Our ref: 25_31312_P

Site Location: Land off Fen Gate Moulton Chapel
Spalding Lincolnshire PE12 0QA

Summary of Proposal: Erection of
Detached Two Storey Dwelling, Annexe &
Garage

TITLE
PROPOSED SITE LAYOUT &
BOUNDARY TREATMENTS

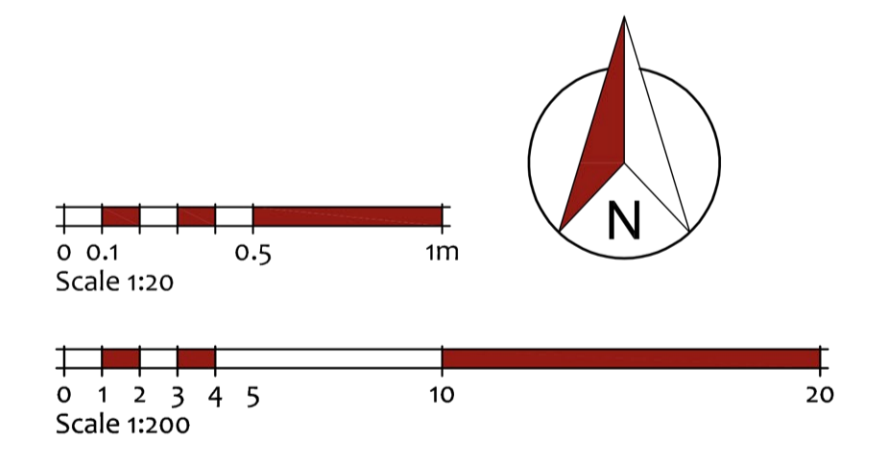
The applicant has indicated that they intend to dispose of surface water via infiltration, however I cannot see that the viability of this proposal has been evidenced. We recommend that ground investigation is carried out to determine infiltration potential, followed by testing in line with BRE Digest 365 if onsite material is considered favourable for infiltration. If infiltration is not feasible at this site, following the drainage hierarchy we would expect the applicant to propose to discharge surface water to a watercourse. In this case, consent would be required under Byelaw 3. Please note that we recommend that any discharge is in line with the [Non-Statutory technical standards for sustainable drainage systems \(SuDS\)](#), therefore the Board is unlikely to grant consent for discharges in excess of greenfield rate. A surface water development contribution is likely to be payable as a condition of any consent granted under Byelaw 3 in line with the WMA's [Development Control Charges and Fees](#).

I note that the applicant intends to treat foul waste using a BioDisc package treatment plant, however I cannot see that the applicant has indicated how they intend to dispose of treated foul water from this development. If the applicant proposes to discharge treated foul water to a watercourse, consent would be required under Byelaw 3.
